**Consultation Response from KC,
Lead Local Flood Authority**

2026/90823 373, Wakefield Road, Denby Dale, Huddersfield, HD8 8RP

Demolition of existing workshop and erection of larger workshop

Date Responded: 17th June 2026

Proposed Ground Floor Plan 1:50 @ A1

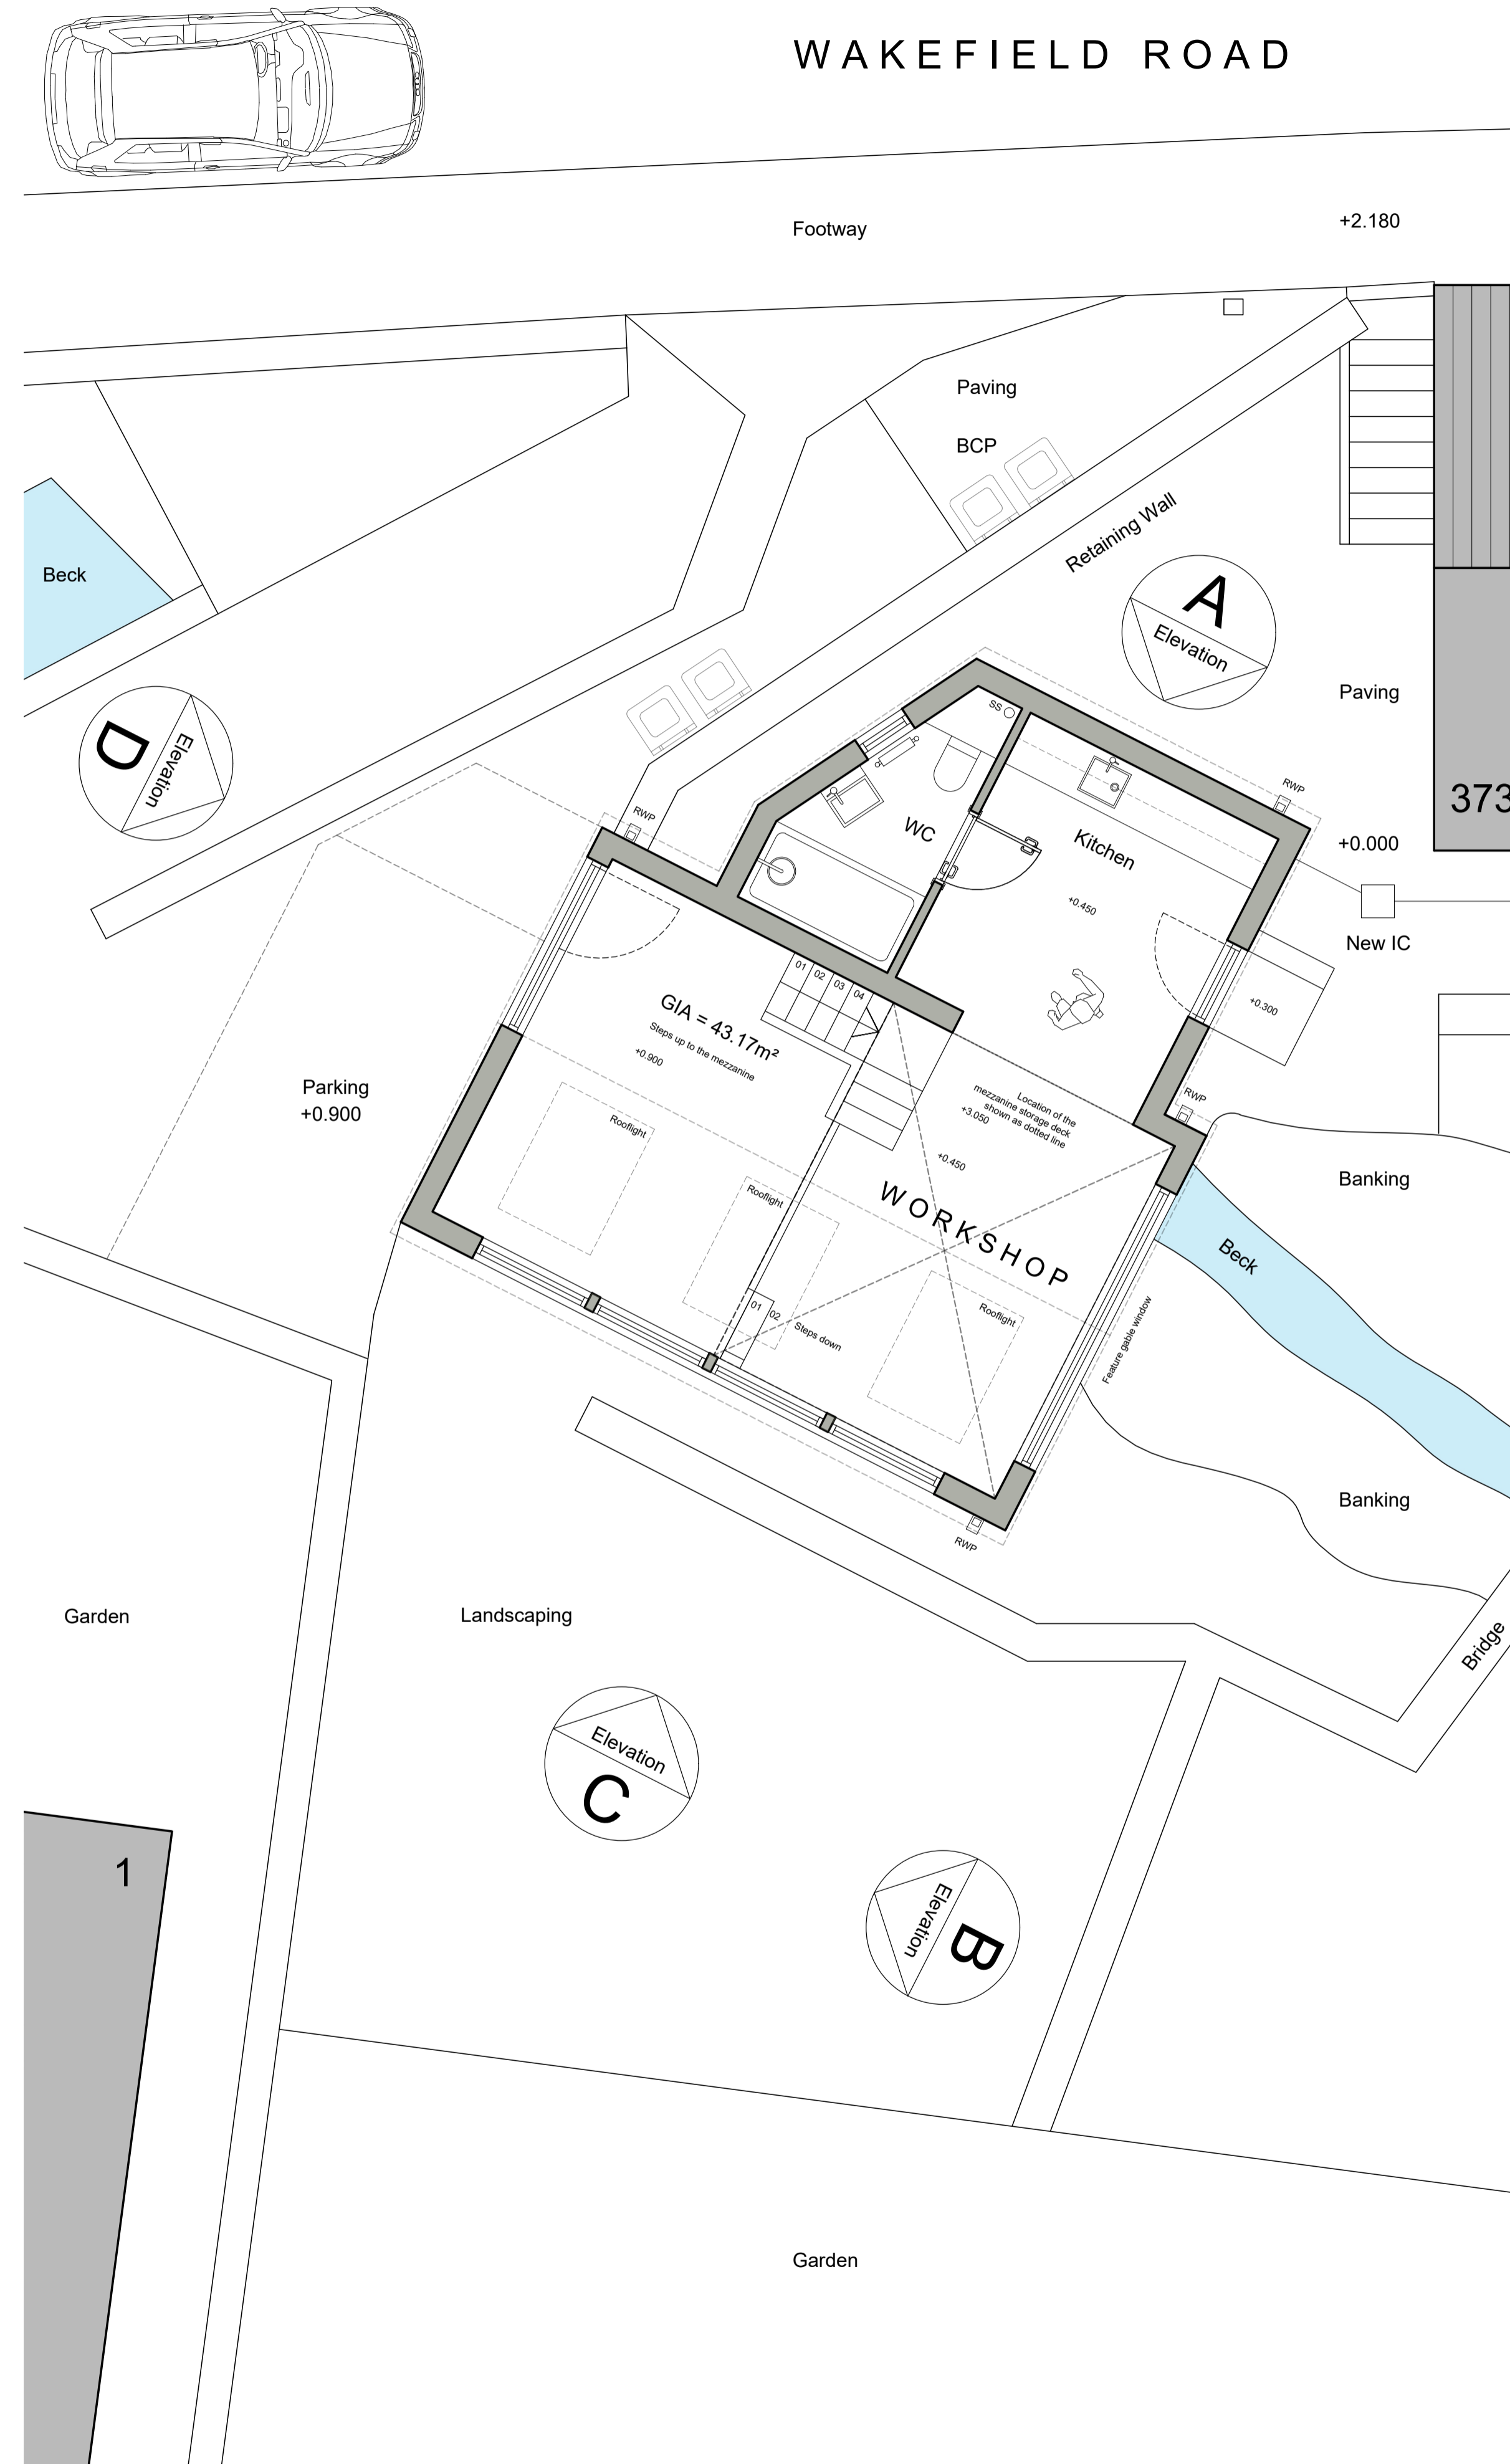
We note that the new build is largely on the original footprint is the same with an addition to the north.

However, the existing building is built over East Hill Beck preventing access to watercourse clearance. This has resulting in flooding due to blockage and backing up affecting nearby properties and the road network.

We would insist that any new build was outside the line of the watercourse with an assessment of foundations to mitigate potential dead loading complications.

Existing Ground Floor Plan 1:50 @ A1

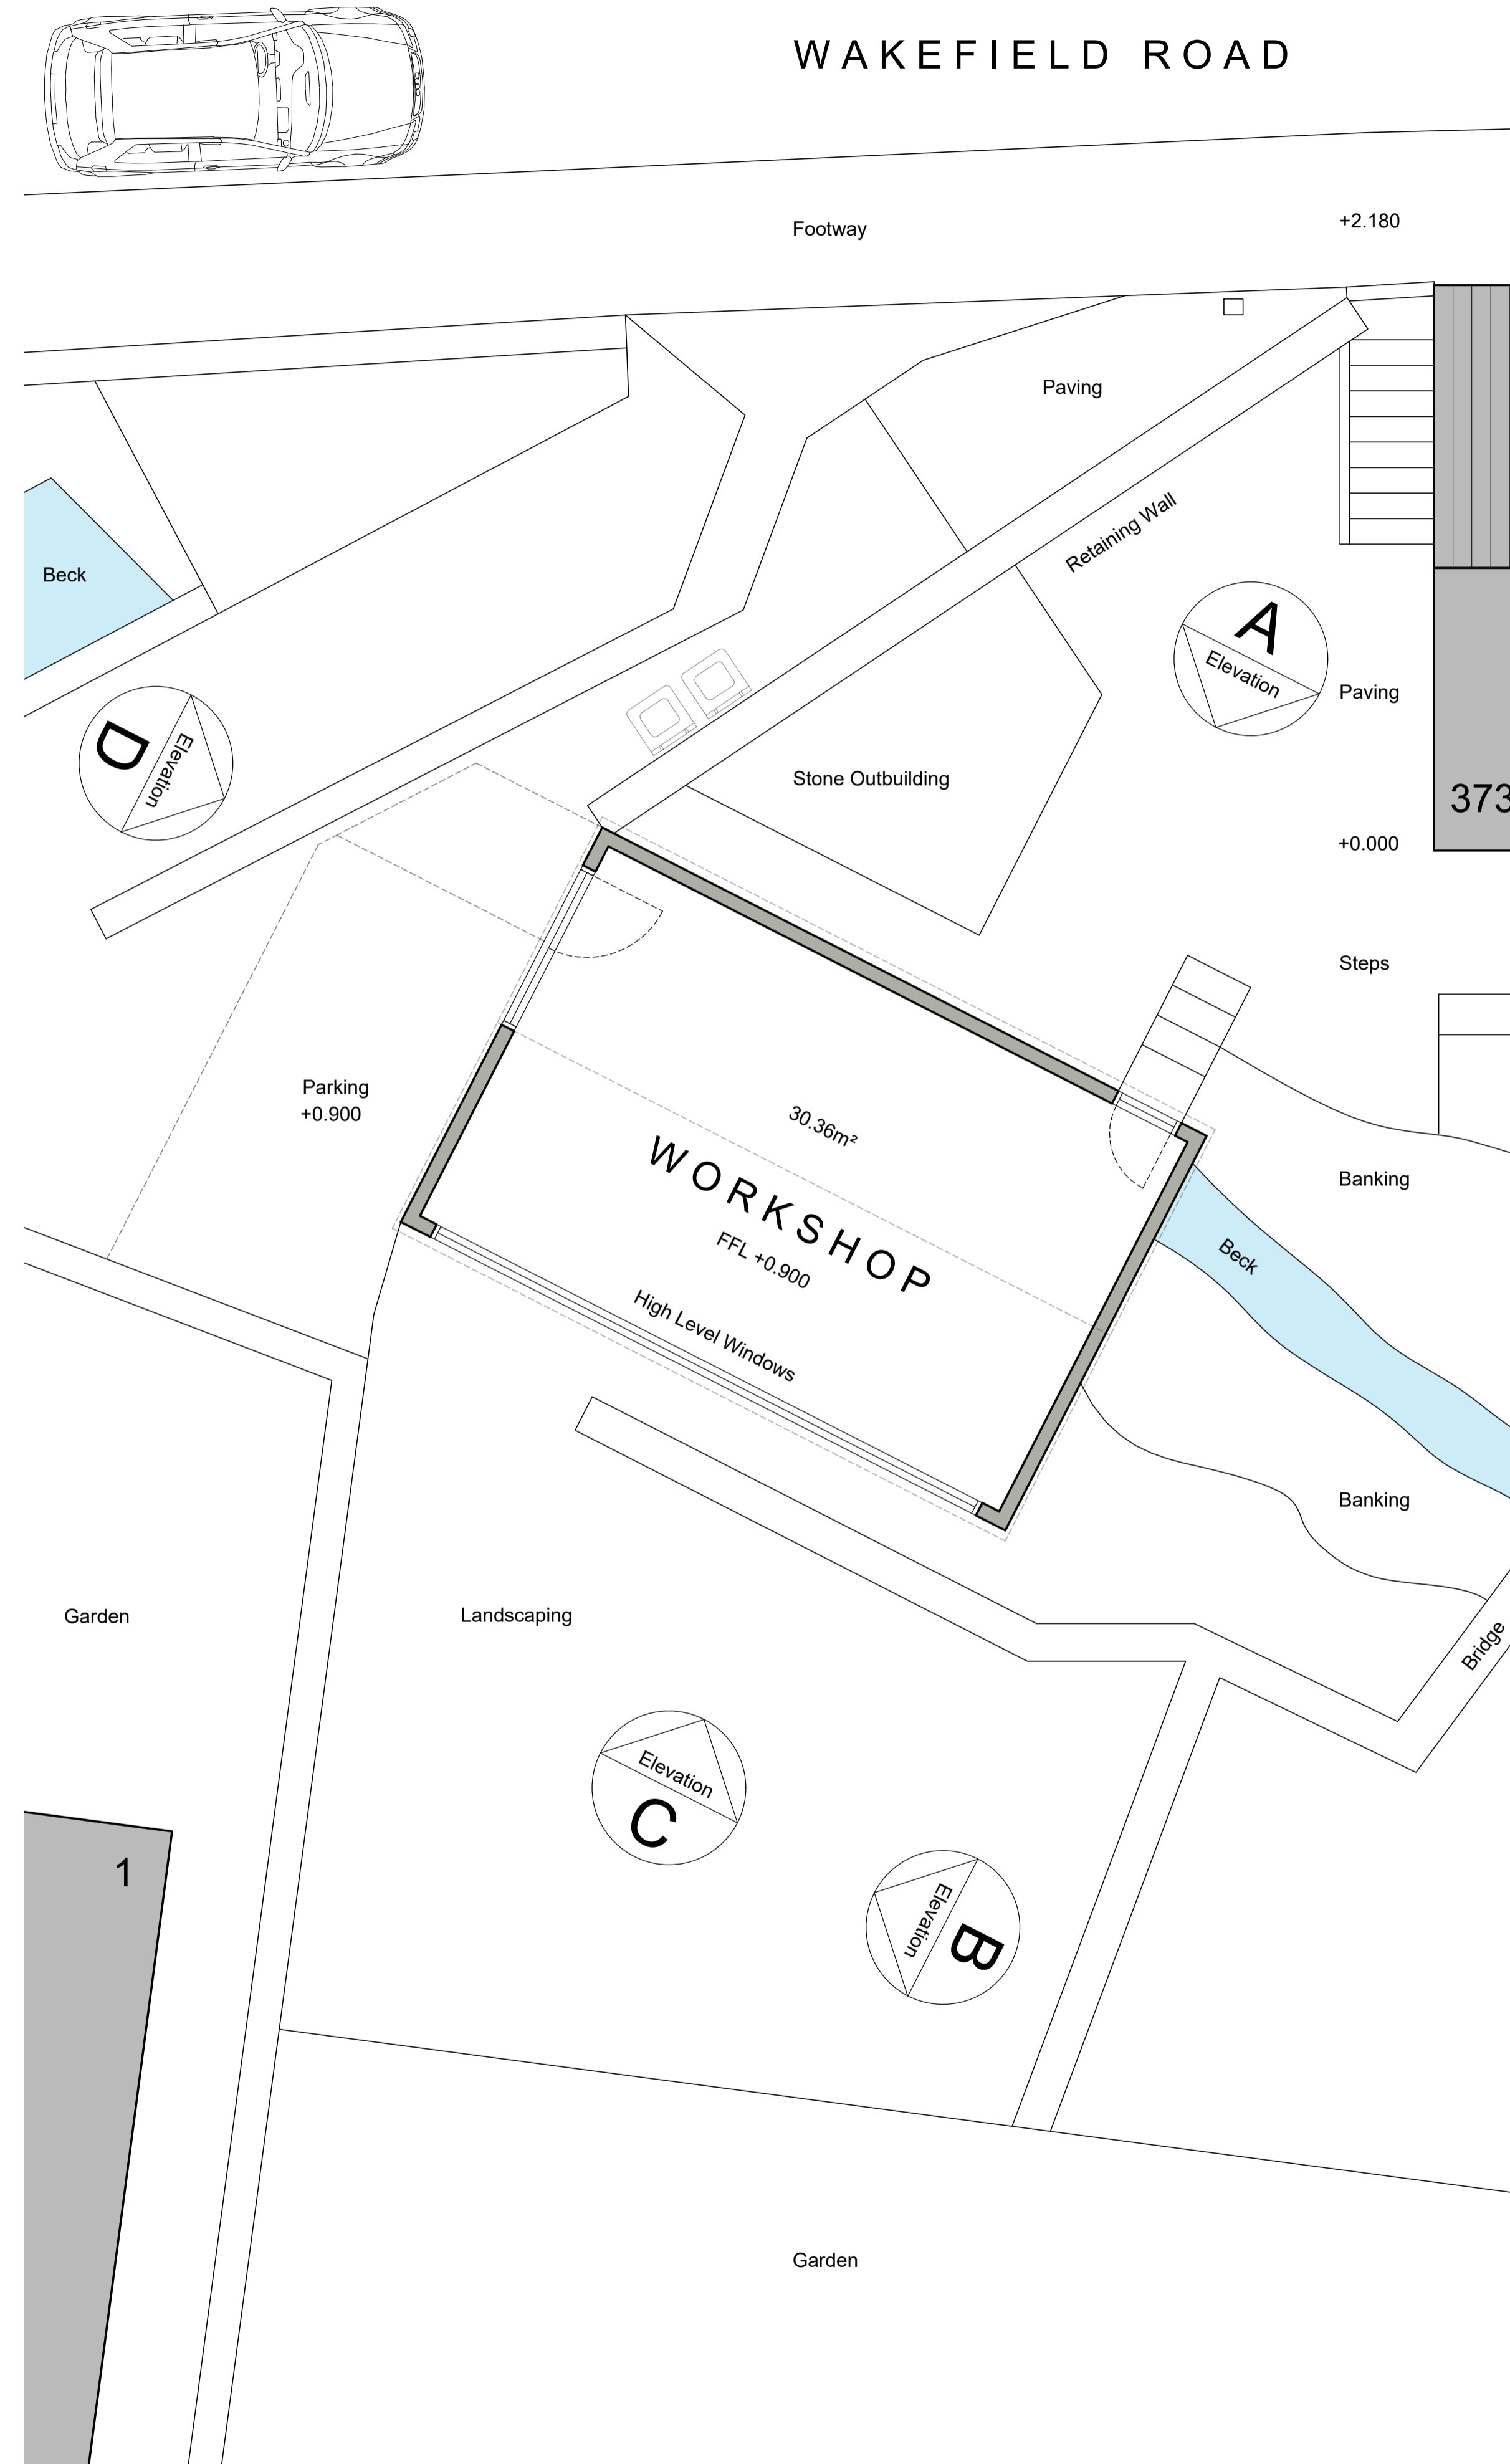
It is Kirklees Council's policy to (de-culvert) open up watercourses. Building over watercourses creates risk and is not encourage from an ecological and biodiversity perspective.

The LLFA would be prepared to consider a redesign that opened up the watercourse, renewed the culvert, if necessary, after an inspection, and created access with a plan to maintain as riparian owners (a watercourse is the responsibility of the person whose land it passes through).
